March 29, 2023

Project No. 21071

**Re: Tree Retention 2207-122 (Design Built Homes - 8427 SE 47th St)
Request for Information
8427 SE 47th St**

TREE RETENTION NOTE

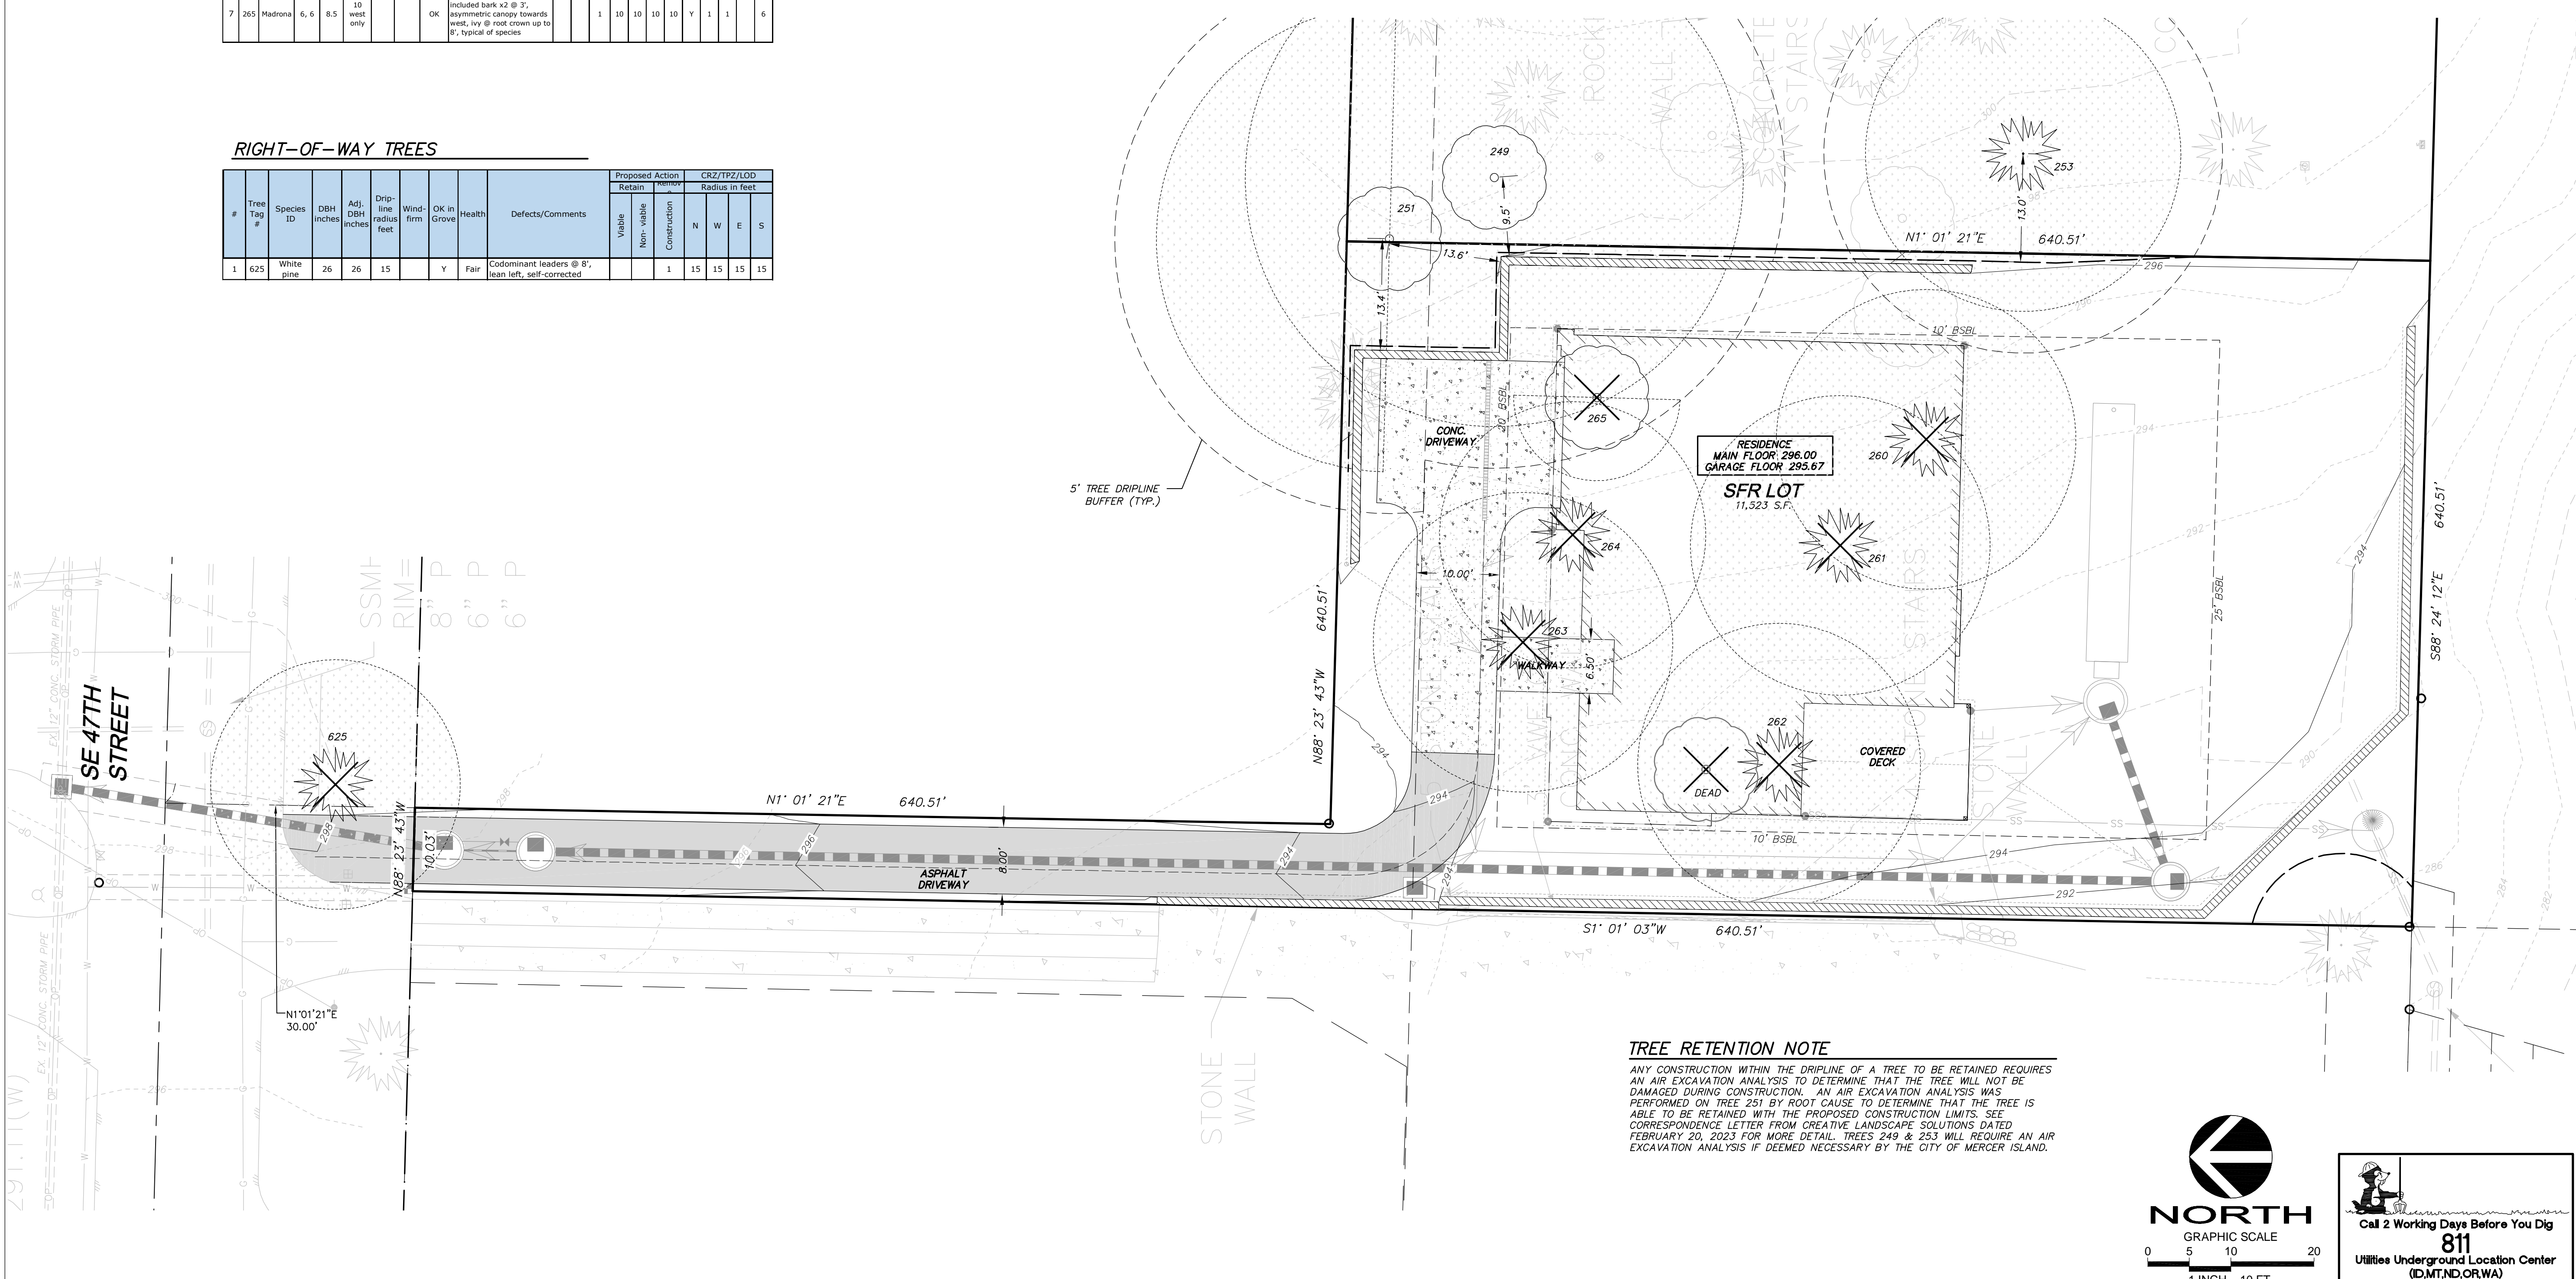
This letter is provided as response to an email dated March 15, 2023 requesting information regarding the location of a retaining wall proposed in the Project mentioned above at 8427 SE 47th St.

The proposed development plans for the Project involve the clearing and grading of the existing Site and constructing a new residence, new utility and drainage connections, a driveway accessed from SE 47th St and retaining walls. The retaining wall in question is proposed at the northeast corner of the Site. This particular retaining wall was proposed to avoid a slope in the northeast corner that would require a steep slope draining down toward the proposed residence. The slope would also require grading within the critical root zone of Tree #251 as well as raising the garage finished floor elevation. The proposed retaining wall eliminates further development in the proximity of Tree #251 (shown below).

In an email dated March 6, 2023, it was stated by Susan Prince, ISA Certified Arborist #1481, TRAQ Certified Arborist #481, that under her supervision, Todd Sherman (the Client) air-
evacuated the soil to expose the roots of Tree #251. There was one 5-inch diameter structural root that was 13 feet from the trunk on one side of the tree and no real structural roots on the other impacted side.

Based on the information provided, D.R. STRONG Consulting Engineers altered the proposed retaining wall to be 13 feet from the property line which is over 13 feet from the center of the tree trunk of Tree #251 (as shown in the image above). If the wall were to move farther west, it would eliminate driveway area leading into the proposed garage. This would create an impossible scenario for the future residents to utilize the entire garage and back out safely without obstruction. If the foundation were to move farther west, it would encroach upon the locations of the proposed sewer and storm pipes.
